Tees CCPP Project

Scoping Opinion

Proposed Teesside Combined Cycle Power Plant

Planning Inspectorate Reference: EN010082

Figure 5.3 Layout of the Main Structures (Scenario One)

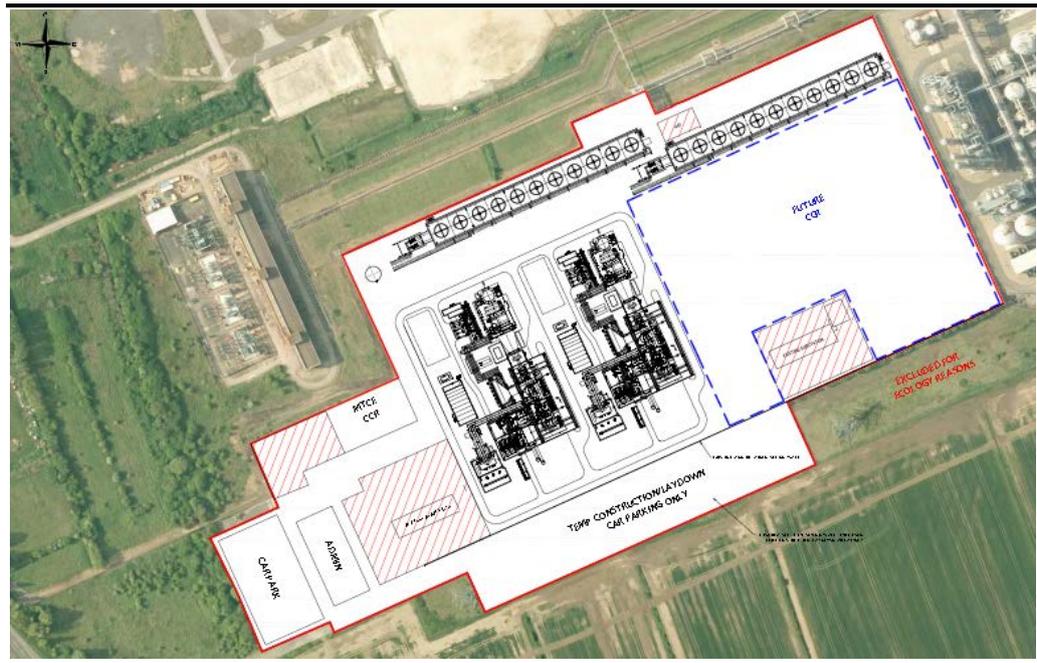
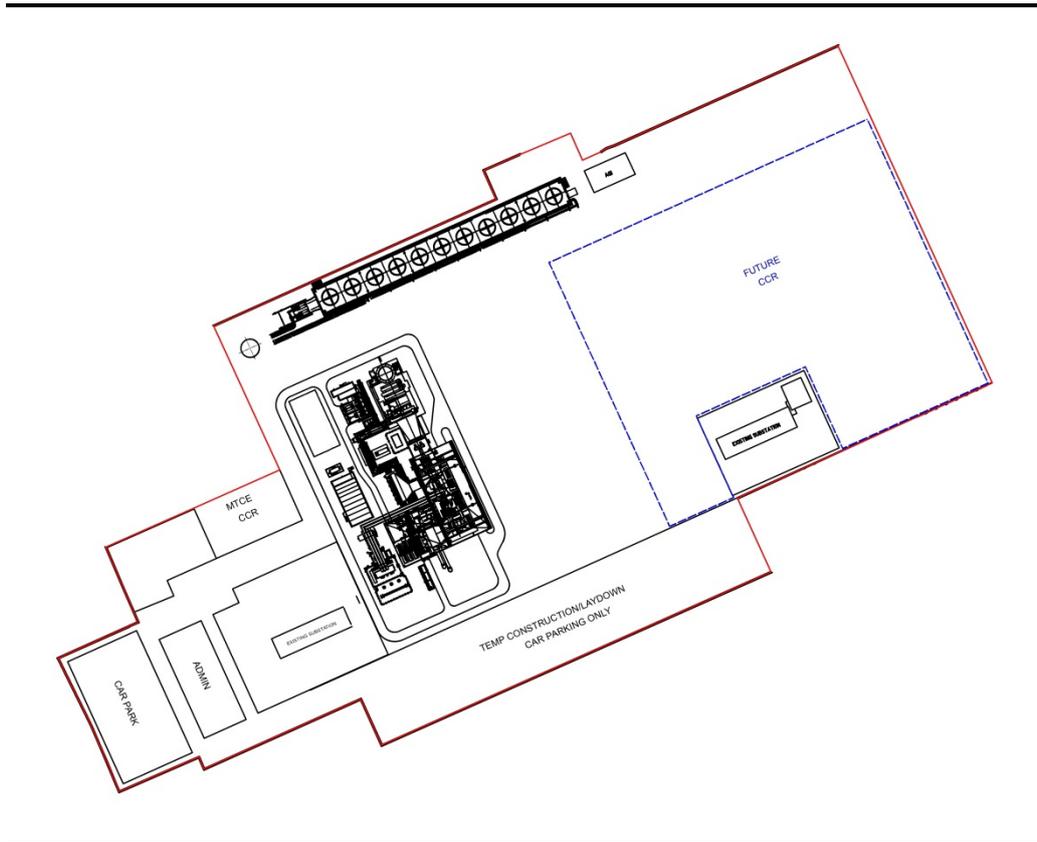
2.42 The key features of the Proposed Development are described in Section 3.3 of the Scoping Report. The inclusion of figures to support the description is welcomed, but the Applicant should ensure that all figures in the ES are provided at an appropriate resolution to ensure

- legibility. For example, the text on Figures 3.2 and 3.3 of the Scoping Report is illegible on both the electronic and the hard copy.
- 2.43 The SoS welcomes the inclusion in the Scoping Report of Table 3.1 (page 13), setting out the approximate dimensions of the main structures of the Proposed Development. The presentation of such information in tabular form in the ES will be helpful. The SoS also notes and welcomes the statement below it that the approach to the assessment will be to adopt a worst case scenario for the topic assessments, including in respect of dimensions. Where dimensions of structures have not been fixed at the time the DCO application is made, they should be expressed as a maximum, and must be consistent with the parameters stipulated in the DCO.
